Your Ref: OWPC23746
Our Ref: K/19/19/HH 25-06-2019
Please ask for:
Zac Denton

Two storey rear extension with a small canopy projecting the footprint to the front.
Demolition of existing living room and additional first floor for habitable use with alterations to fenestration.

Little Tangle Middle Way Kingston Gorse East Preston

Thank you for your internet representation made on 23rd July 2019 which has been recorded as '**an objection**' with the comments as follows:

Proposed Section AA

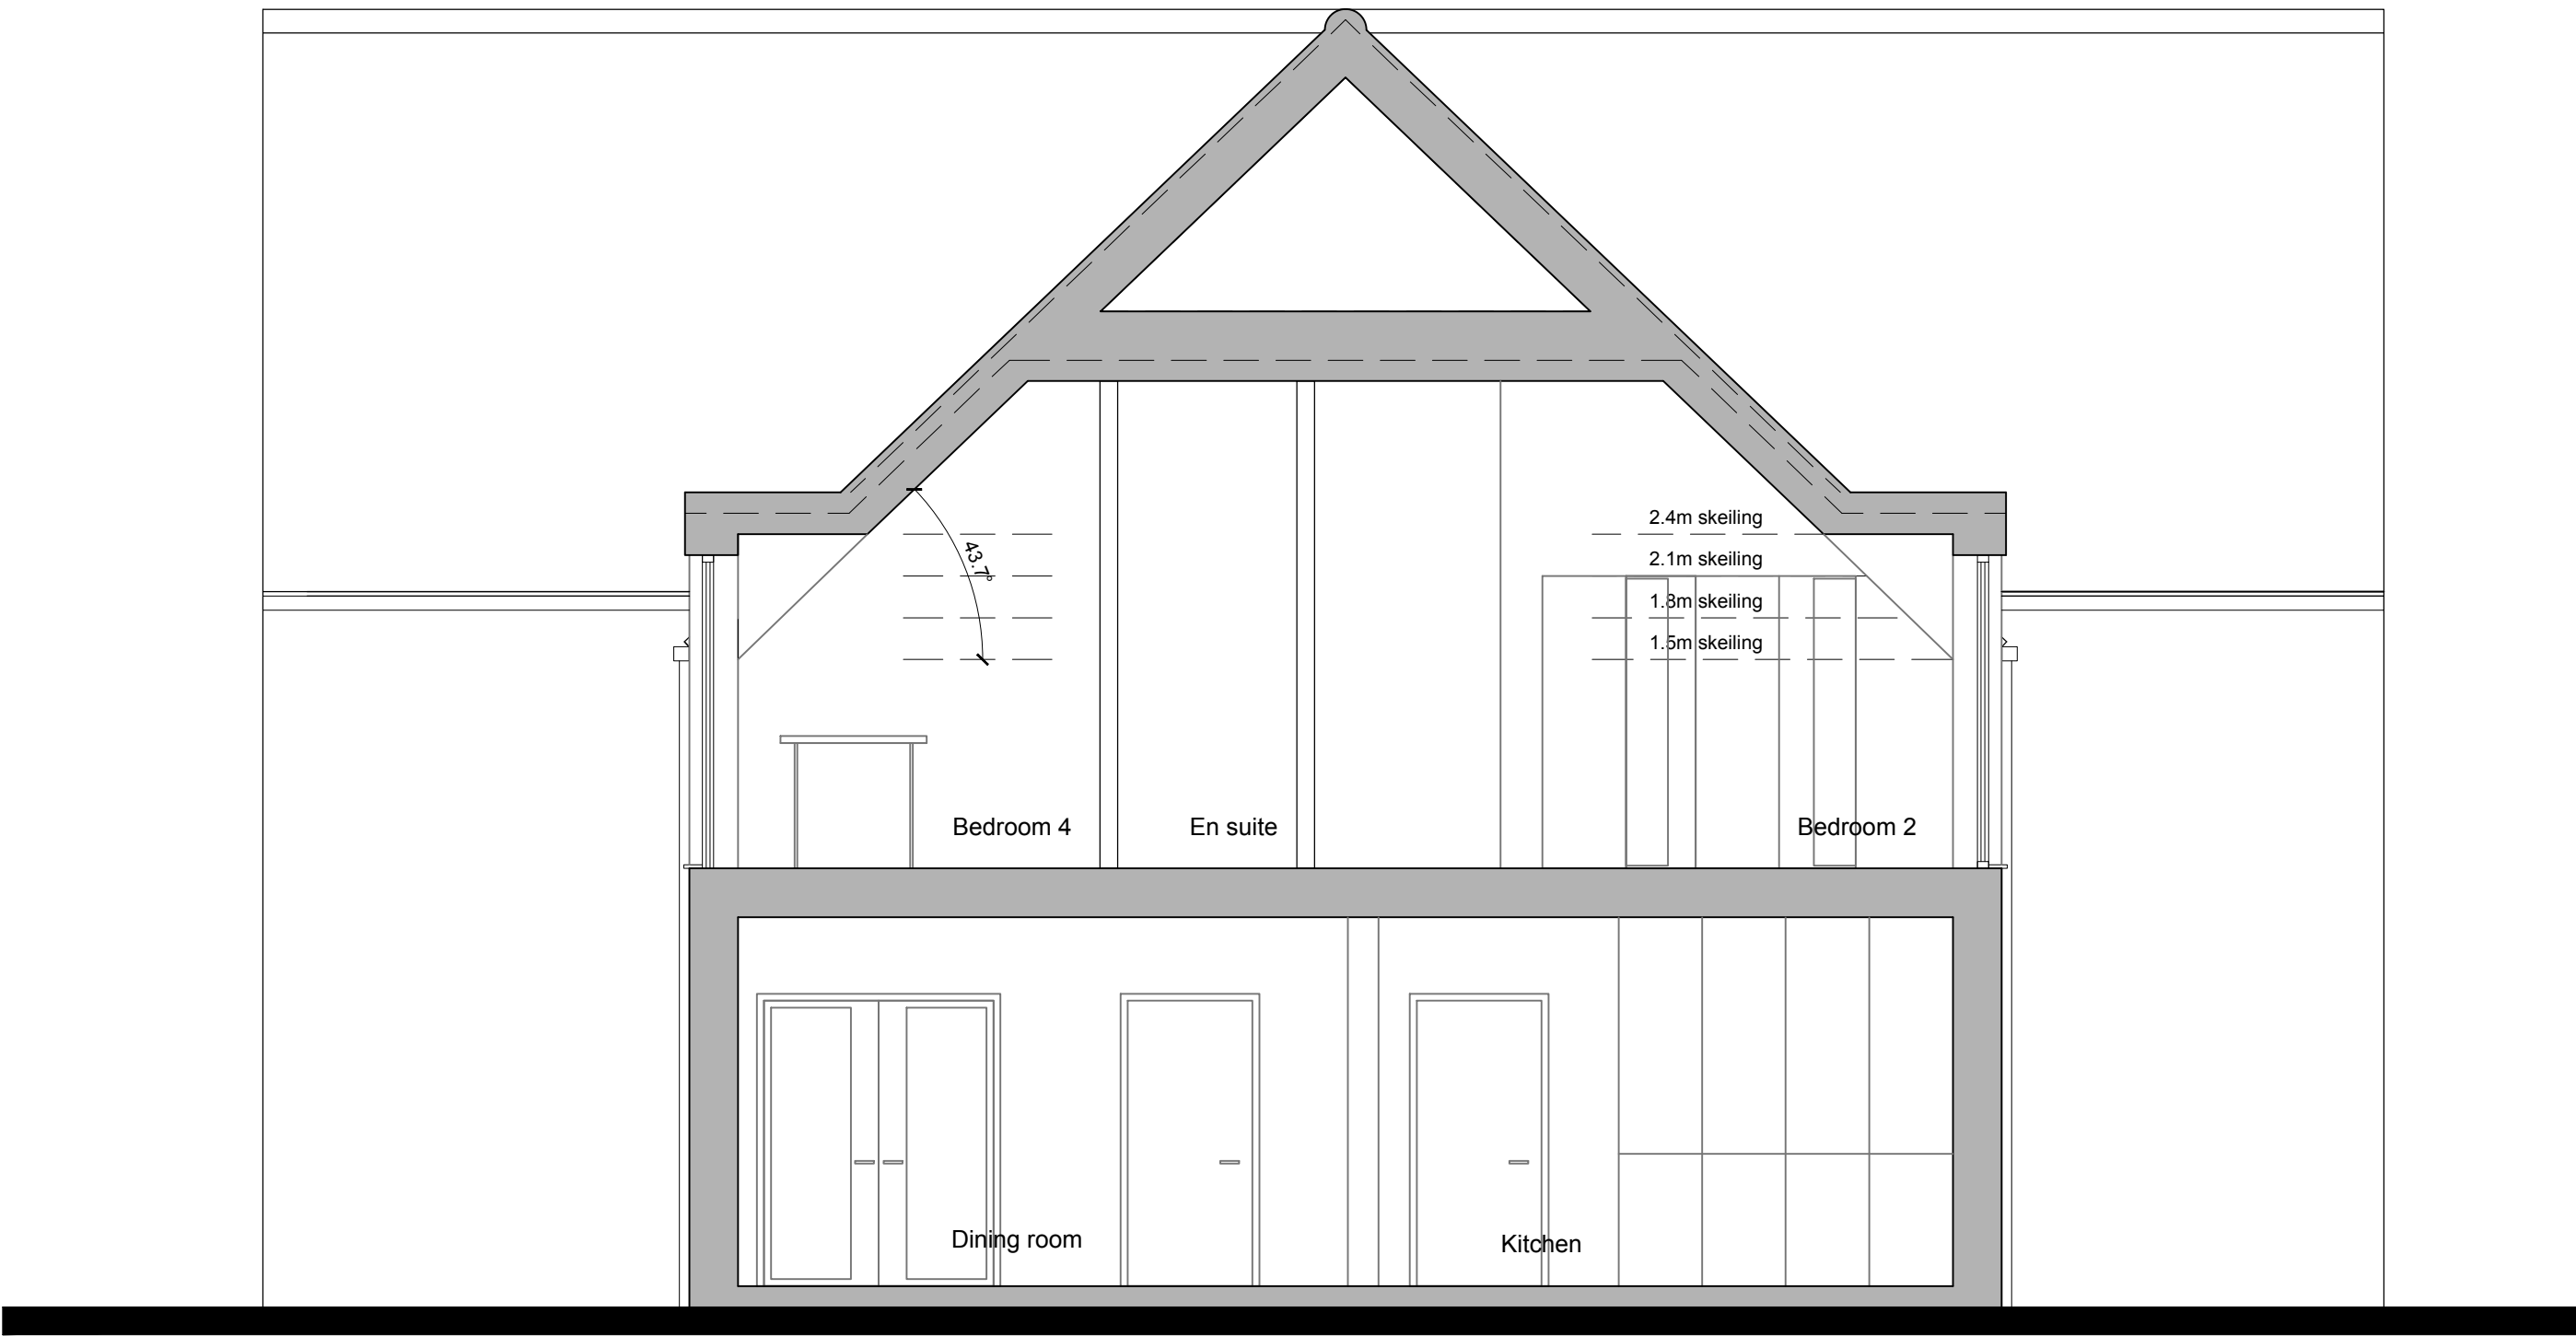
2. The building ridge height is currently c12m and the proposed ridge height is c15.4m, an increase of 3.4m (a 28% increase). Our ridge height is 13.4m.

It is unclear how such a significant increase in the ridge height can be considered as an extension. The 2018 planning application for The Poynings required our small side extension (which did not overlook the neighbouring property) be subservient to the existing building. This required the extension ridge height to be reduced to 50cm below the existing. This resulted in a material compromise in the upstairs extension creating a very low skilling 50cm lower than was anticipated.

If the planning rules are applied consistently the maximum ridge height for this extension, should be c11.5m.

3. The ground floor m2 footprint is unchanged but the shape of the footprint is different. The proposed rear development extends the footprint beyond the current building line and that of The Poynings. It would be a 2-storey extension 3.4m higher than it is today and 2m higher than The Poynings.

We believe the rear balcony gable would extend at least 1.5m beyond the line of The Poynings.
